Online Comment

Application	H04-0268-20
Location	Land to the West of Malting Lane Donington Spalding
Proposal	Residential Development of 40 dwellings - outline approval H04-0244-16

Name	Angela Doherty
Address	Housing Strategy

Date Submitted	09-03-21
For/Against	Comments

Drawing Title:
Tenure Arrangement

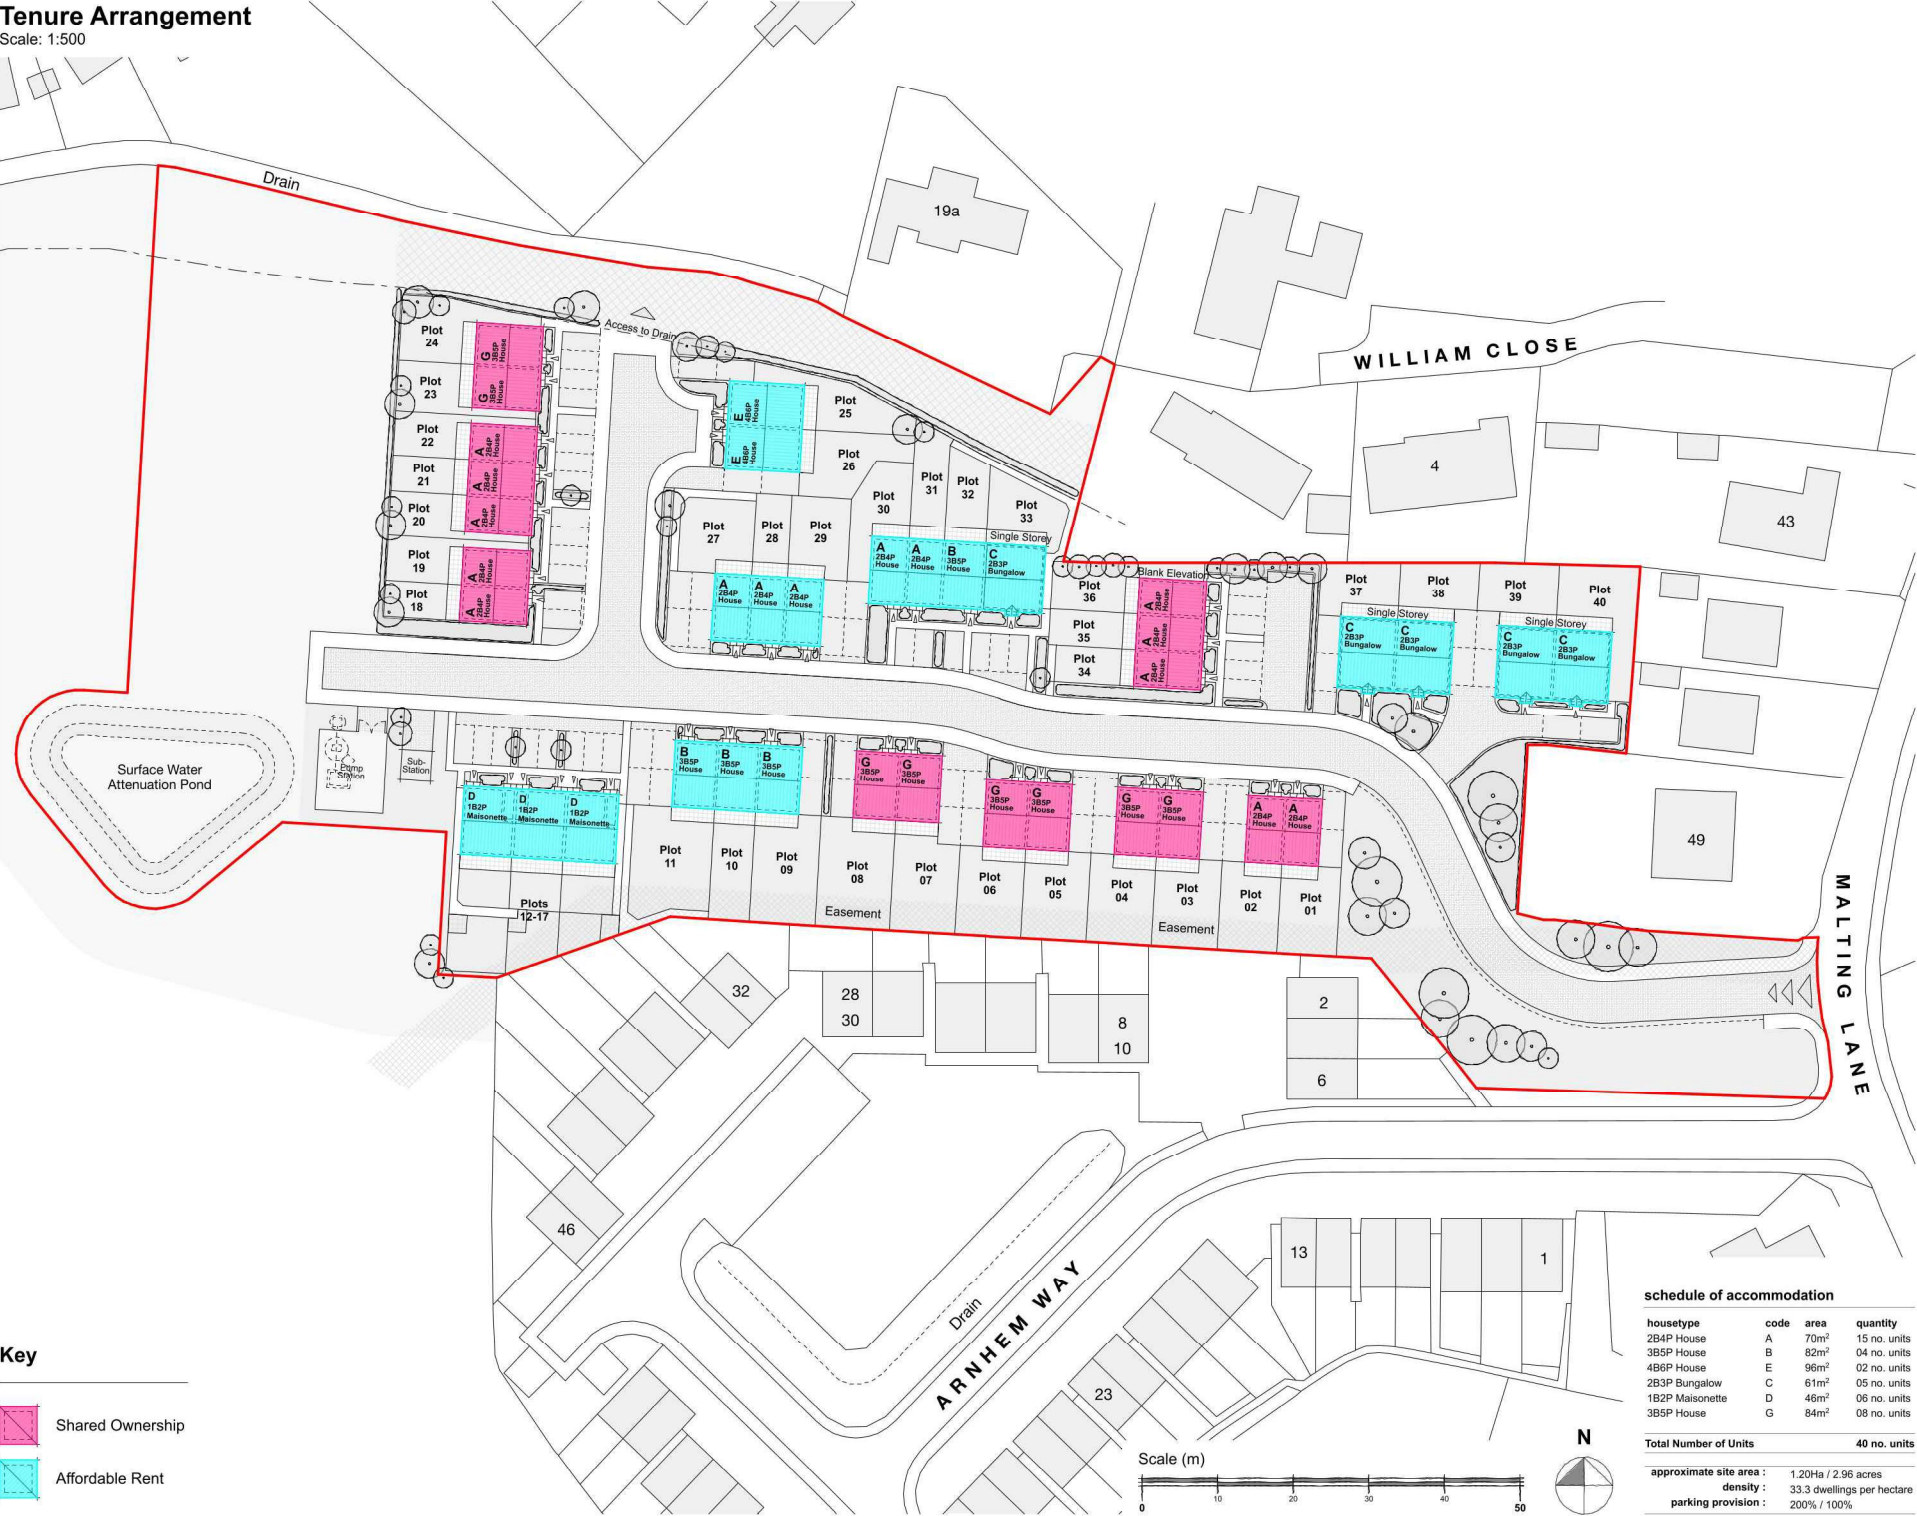
The applicant has submitted a tenure arrangement plan which proposes 29 Affordable Rented homes, comprising of 6 x 1 bed maisonettes, 10 x 2 bed houses, 4 x 2 bed bungalows, 7 x 3 bed houses and 2 x 4 bed houses & 11 Shared Ownership, comprising of 5 x 2 bed houses and 6 x 3 bed houses. This equates to a 73/27% tenure split in favour of Affordable Rent, which broadly accords with the 70/30 tenure split in the Affordable Policy, however on all affordable led schemes it is recognised that the tenure split is often more balanced to support a diversification of tenures to create mixed and sustainable communities.

It is not clear from the plans what internal sizes the affordable homes are, ideally these should be built to the nationally described space standards, although this is not a requirement in policy. Can we clarify with the applicant what sizes they propose and whether any of these will be built to M42 and M43 standards?

The 2 bed bungalows proposed will potentially assist in meeting the needs of the districts ageing population, however it would be recommended that these form part of the Shared Ownership rather than Affordable Rented mix.
